Catherine-de-Barnes Residents' Association

Response to written and verbal representations made at Deadline 2

1) HE Lighting Technical Note Published 27/6/19

M42 Junction 6 DCO – (scheme TR010027) Document Junction 5A Operational Assessment – published June 2019

Drawing Number HE551485 -ACM -HLG -M42_GEN_ZZ_ZZ-DR-EO-0008 I Originator I Volume Rev P04
Highways England PIN 1:1250@A1; 1:2500@A3
Location I Type I Role I Number

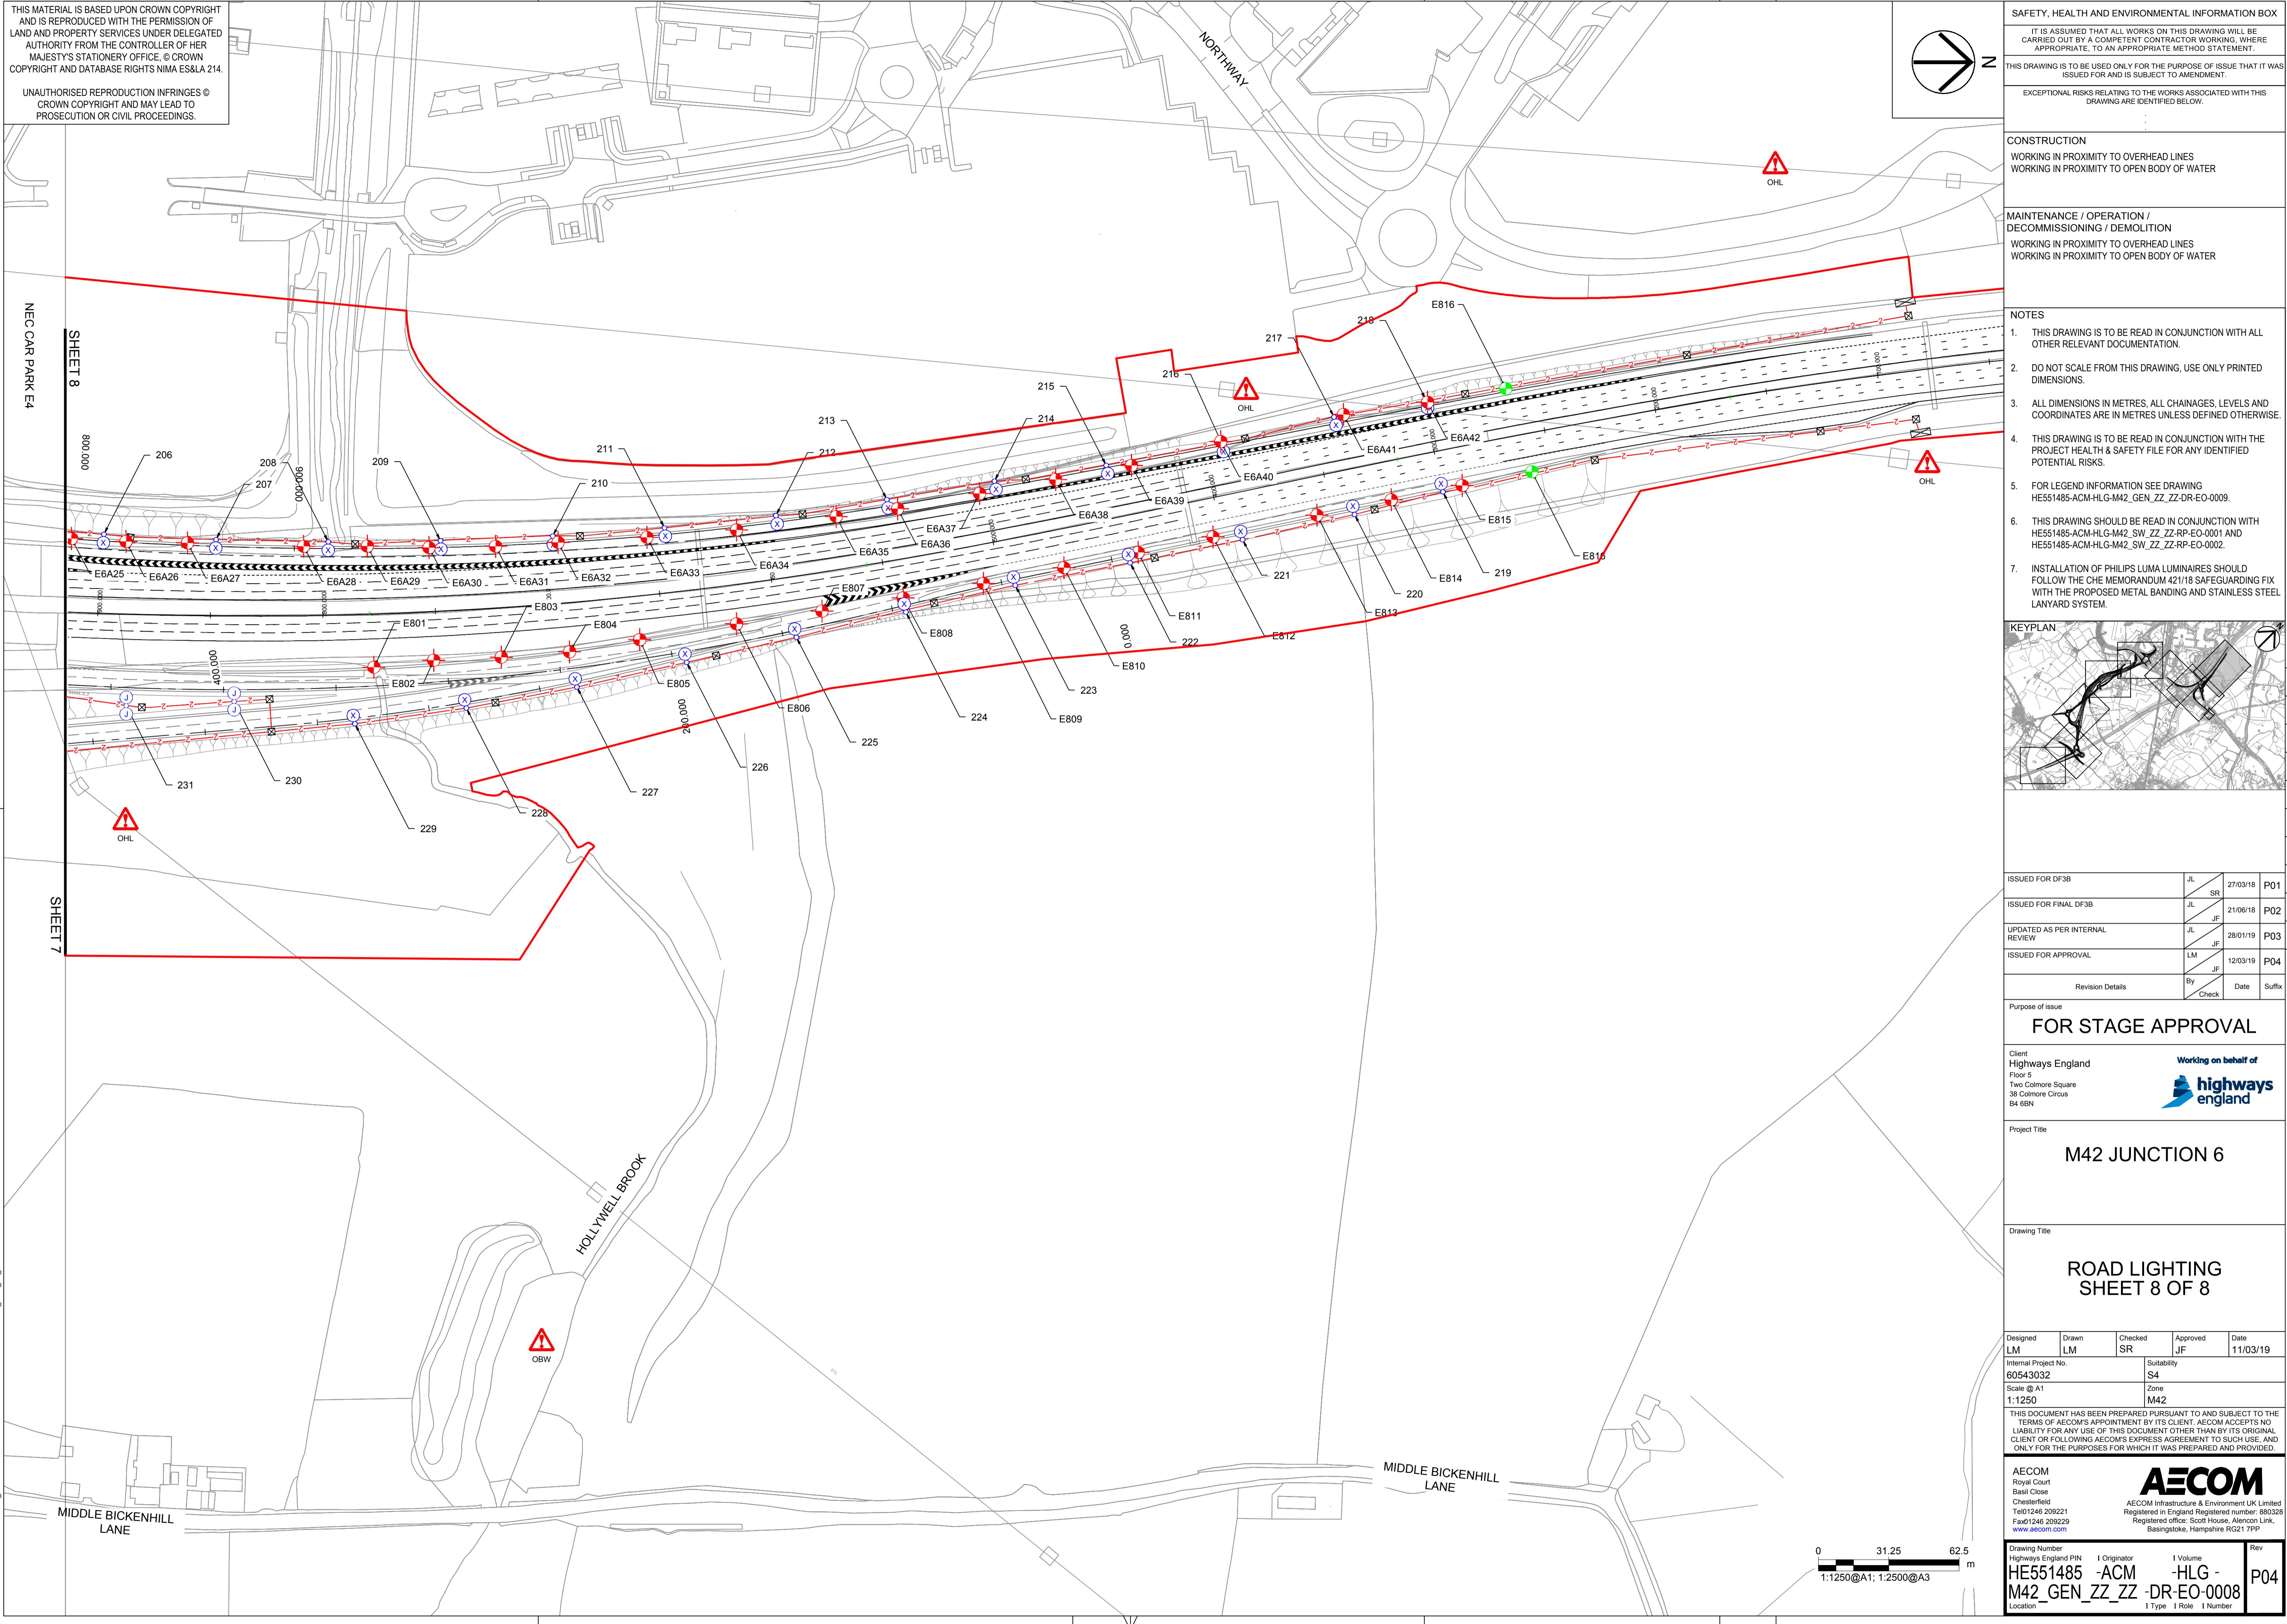
We note that it is the intention to light Barbers Coppice Roundabout and the entry/exits off it but Bickenhill Roundabout and Catherine de Barnes Lane North Overbridge are not to be lit largely because of the environmental /social impact – the surrounding lanes are not lit. Currently Catherine de Barnes Lane (where the Barbers Coppice Roundabout (BCRT)is to be sites) is not lit and we challenge the decision to light it as proposed. From our recollection the speeds of traffic at the BCRT is likely to be 40/50mph but that traffic approaching the Bickenhill Roundabout could be at speeds

of 70mph which would suggest that for safety reasons this roundabout should be lit. The lighting of BCRT severely impact the property of Four Winds. There appears to be further contradiction vis a vis the M42 Southbound Diverge Slip for Jct 6. There will be an apparent saving of 0.13PIA's in year 1 (3 PIA's in yr30) and has a BCR of 2.36 which is described in Table 5 Conclusions and Recommendations – page 17 as a “low BCR” and HE recommends that *“although BCR highlights street lighting is not justifiable for the slip road”* it is recommended for safety reasons.

In comparison Barbers Coppice roundabout will apparently save 0.09PIA's in year1 (2 PIA's in 30 yrs) both figures lower than the M42 Southbound diverge mentioned above. The Coppice Roundabout has a BCR of 2.2, again lower than the slip road mentioned above, yet HE recommends it being lit. There appears to be a distinct lack of consistency and reasoning in arriving at this Lighting Scheme.

The proposed lighting scheme has not been the subject of or included in any public consultation.

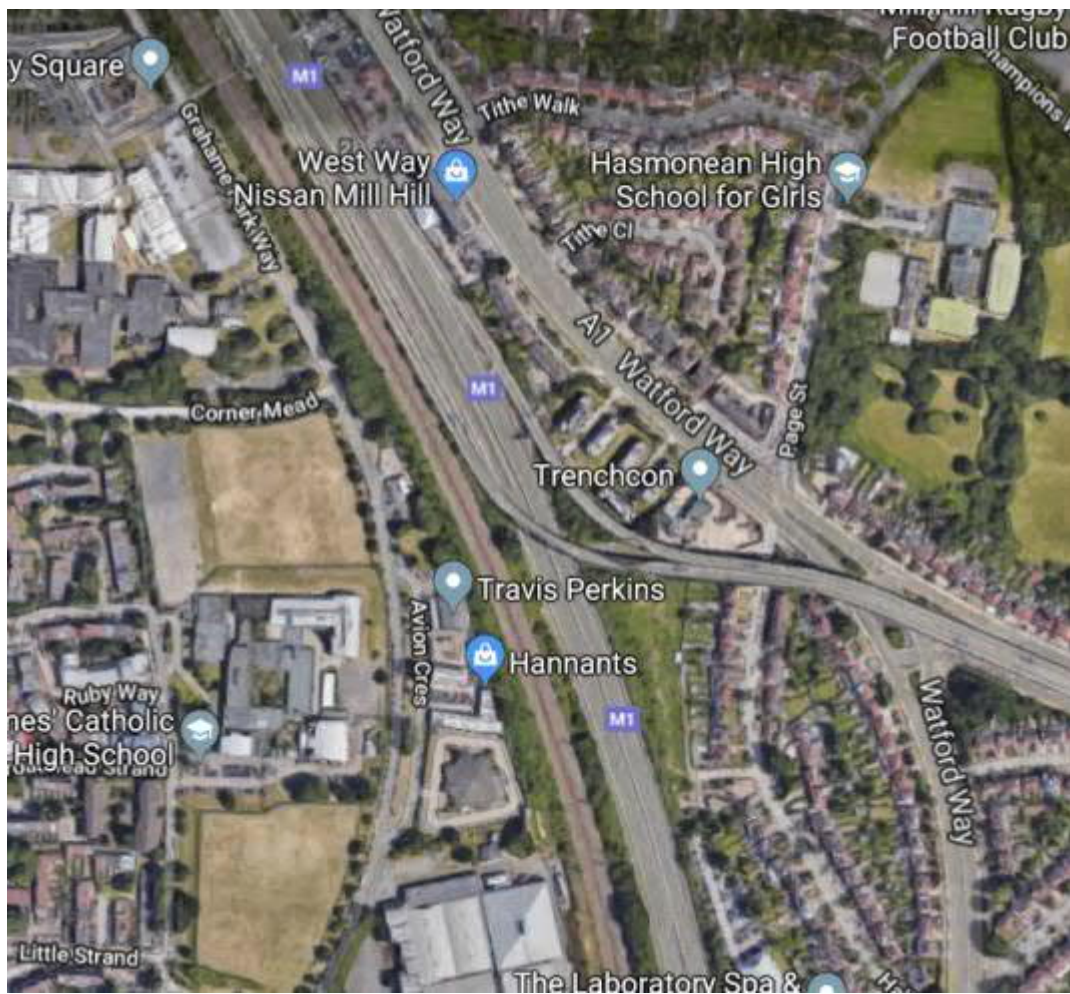
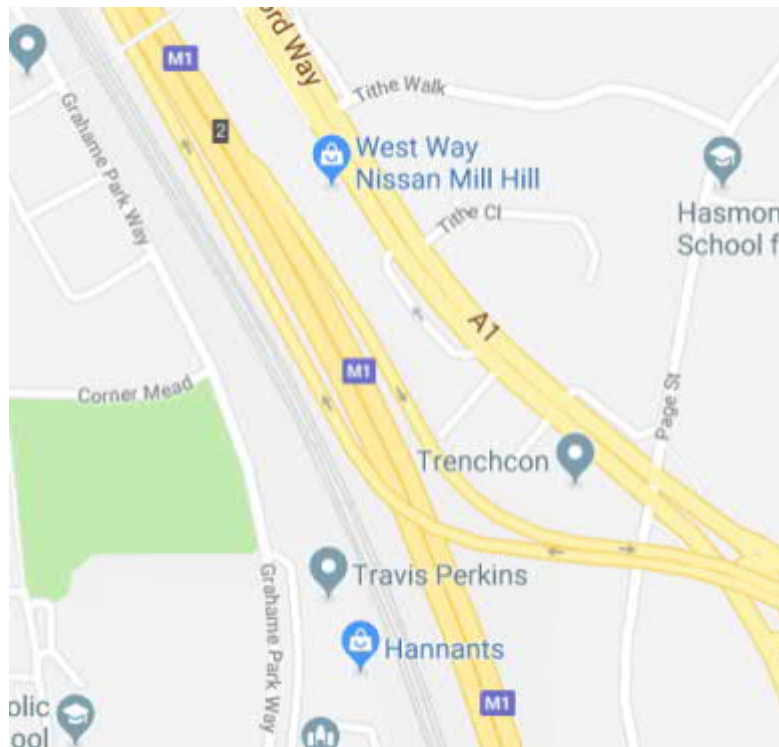
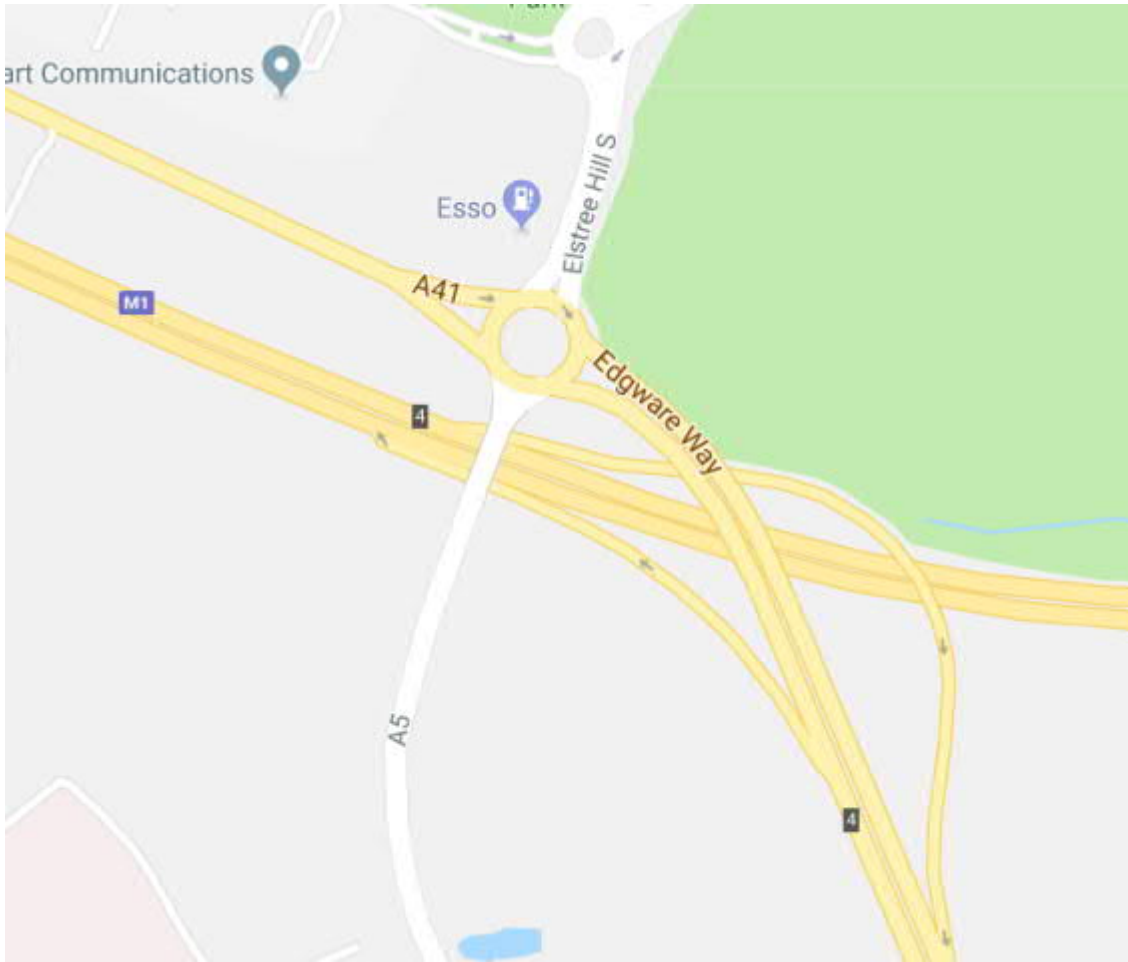
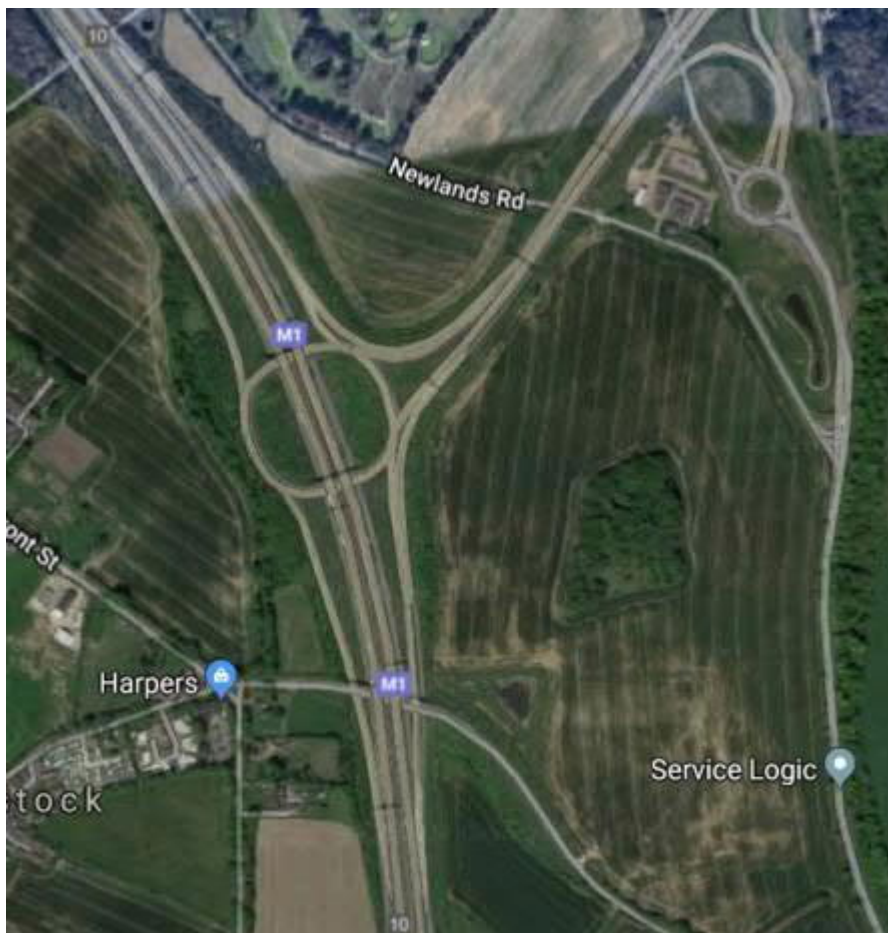
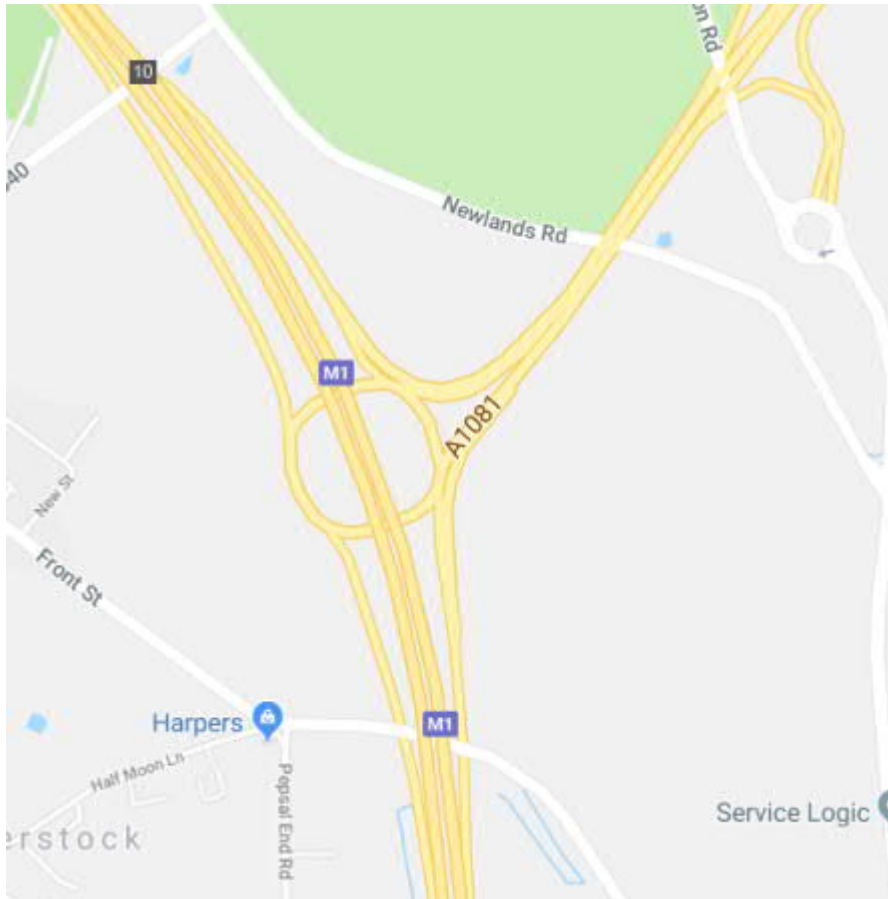
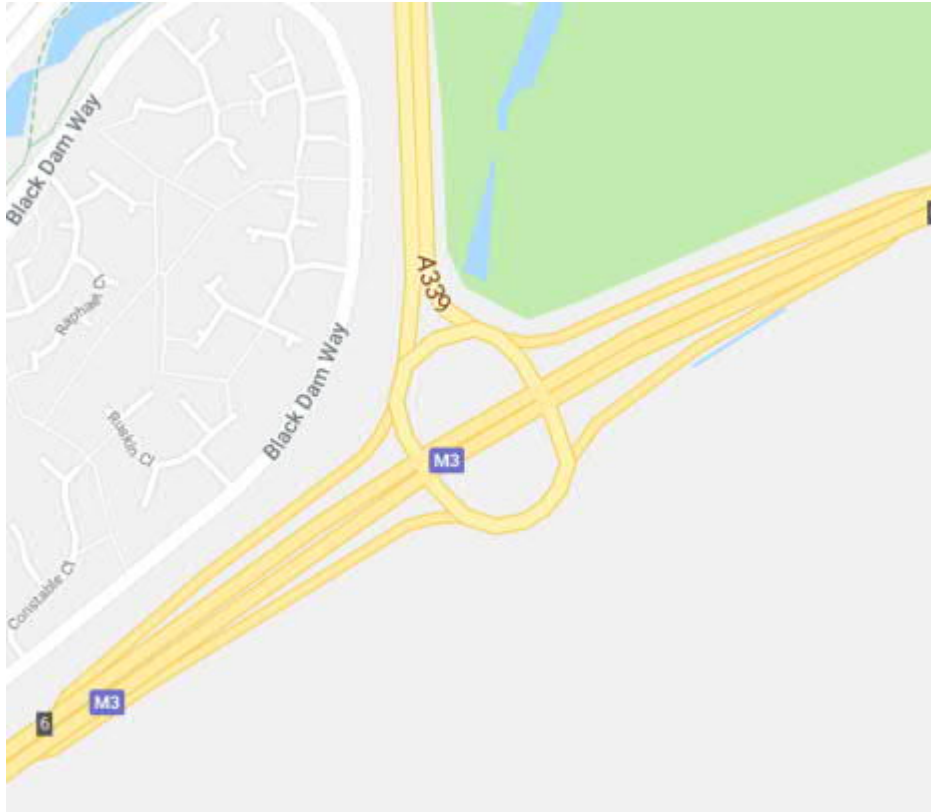
We challenge the statement in the response made by SMBC to this question.1.0.10 which says “.....HE do not consider that it(the rough design submitted) would meet their standards and non- motorway vehicles would not be able to exit at the Clock junction.” Rough design we submitted is a common feature of many free flow junctions on the motorway network (we refer to Applegreen’s response which outlines numerous examples) and fail to see how it could not be designed to meet HE standards. With regard to the issue of local traffic not being able to exit at The Clock. Our diagram represented simple ingress/egress slips off/on the M42, we are not suggesting removing any of the other infrastructure (Barbers Coppice roundabout for instance) that allows local traffic to reach /exit the Clock interchange . The comment by HE included in the SMBC response is inaccurate and incorrect.
